Application number: 2024/90769	
What is the application for?:	Erection of one detached dwelling and associated works
Address of the site or building:	adj, 27, Riley Park, Kirkburton, Huddersfield, HD8 0SA
Postcode:	WF4 5NF

Type of comment: An objection	
Do you wish your comments to be published on the website anonymously?	No
I am writing to object to this planned development on the grounds of development site instability, visual and residential amenity, trees and flood risk. Instability of Site I have serious concerns regarding the stability of the banking on which this proposed development sits. It is clearly unstable and there is the potential of collapse and landslip. The building is proposed to be built very close to the 'cliff edge' of the banking. The proposed development being significantly larger than the previous application raises increased concerns about safety and stability of the land to be built on. The proposed development also now has a basement level which will require excavation into the banking. There is no scheme of works attached showing how this will be achieved and how the building will be constructed safely. The site is on an area of previous coal mining an

Section FF
Scale: 1 : 20

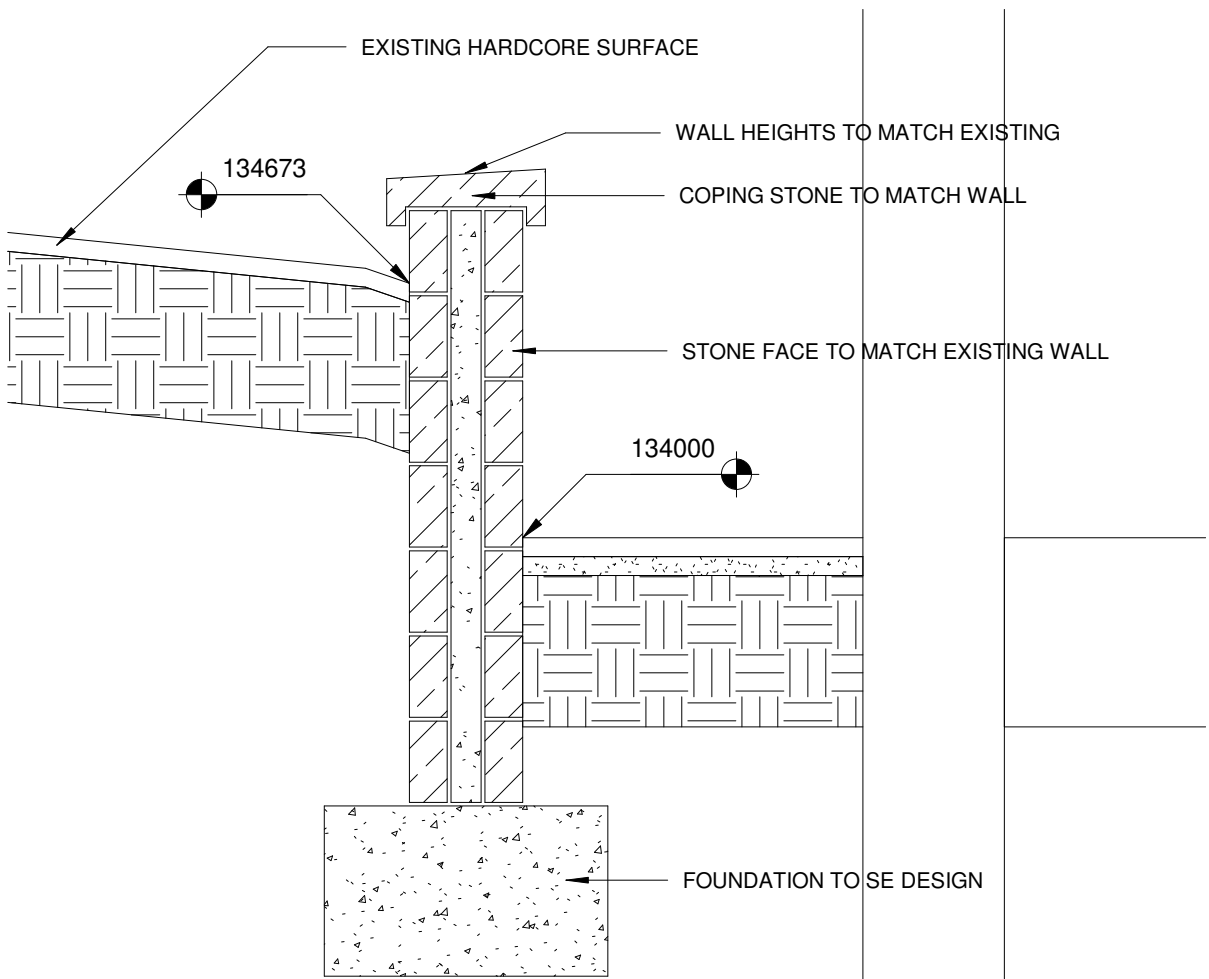
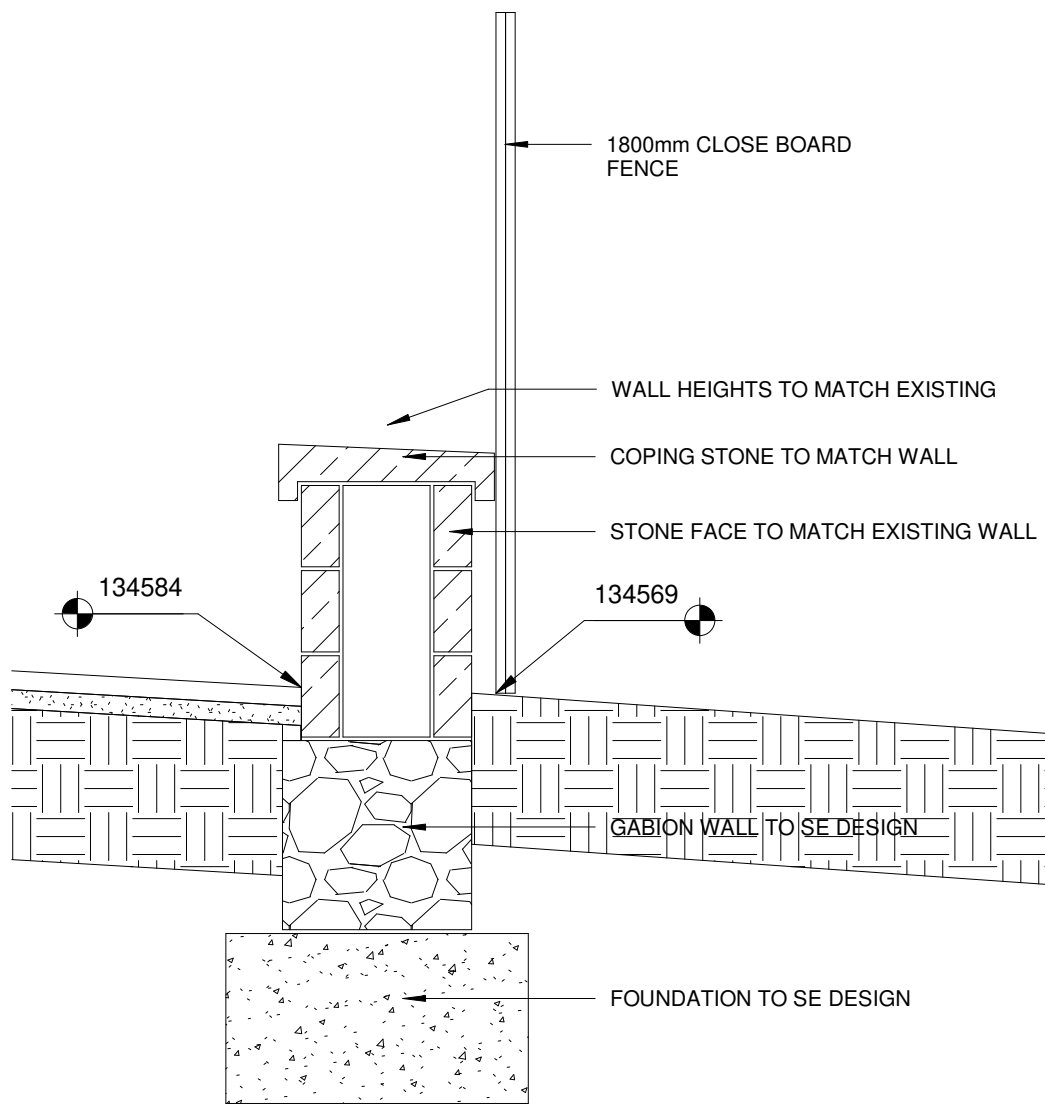
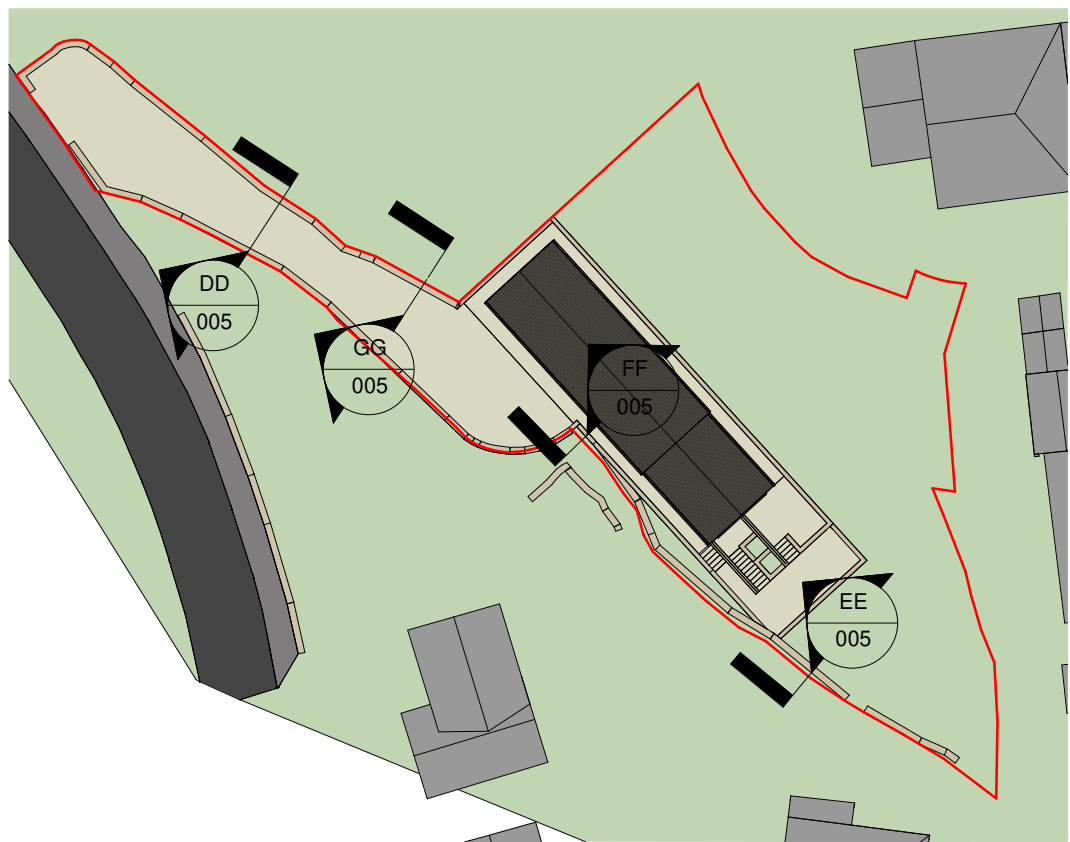
The proposed fencing of closed mesh with scaffold construction will resemble security fencing and again is not in keeping with the immediate area and will be visible and overbearing to neighbouring properties.
